Application number: 2024/91524	
What is the application for?:	Erection of two detached dwellings
Address of the site or building:	Land at Old Lane /Taylor Lane, Scapegoat Hill, Huddersfield, HD7
Postcode:	OL1 3NJ

User comments

PROJECT:	Plot 1, Taylor Lane, Scapegoat Hill, Huddersfield			
CLIENT:	Mr. S. Gaunt			
DRAWING:	Proposed House Type - Elevations			
DRAWN BY:	GG	CHECKED BY:	--	CREATED: 22/05/2024
SCALE:	1:100 @ A3			
STATUS:	Developed Design		DRAWING No: 1483/P-201	REVISION:

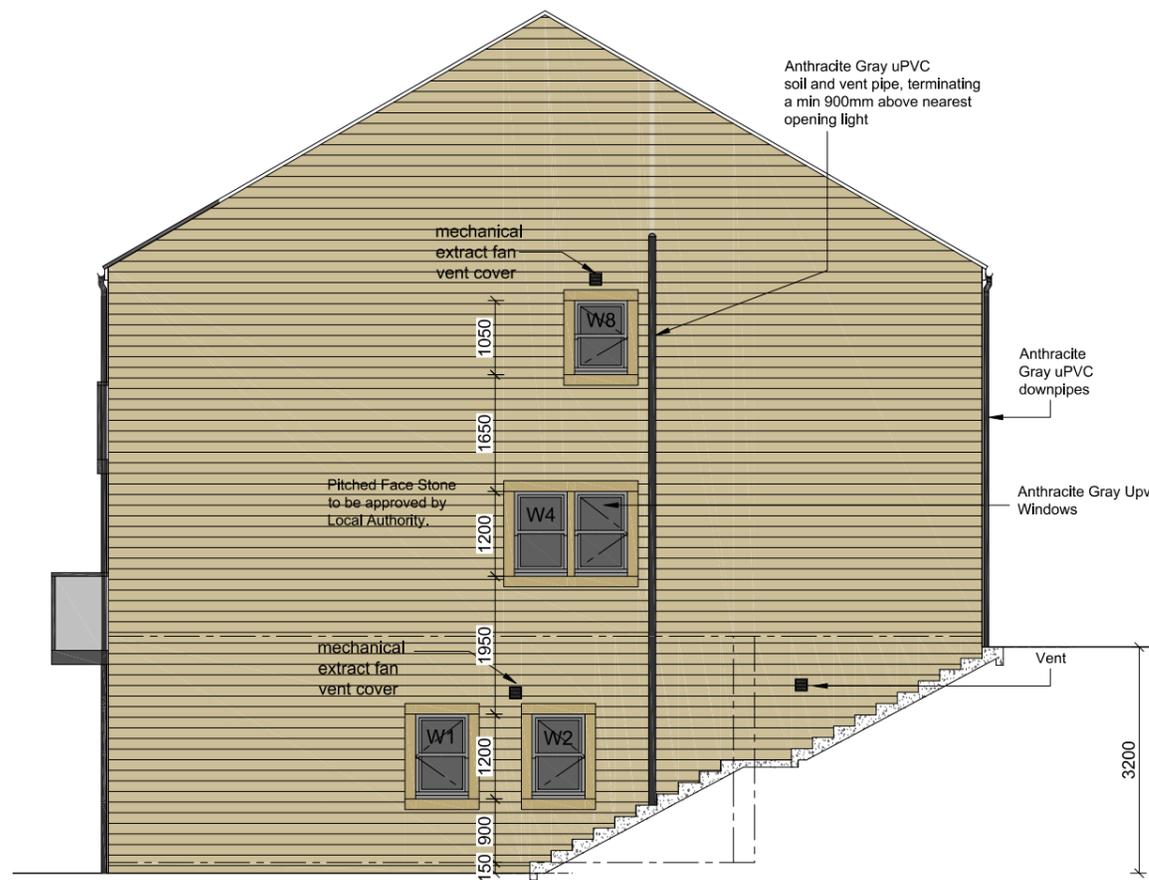
Type of comment: A general comment	
Do you wish your comments to be published on the website anonymously?	Yes
<p>Whilst I would like to see the vacant site developed and have no issue with two houses being built, i would like to see the relationship of the ridge line in proportion to the existing house (4 Old Lane), as anything higher would impact my view? (the existing house is marked as ridge height of 314.44 on plot 2)</p> <p>Also i would hope that KMC would enforce all road improvement works on Old Lane / Taylor Lane prior to commencement so that the developer/contractor does not leave work incomplete as previous?</p>
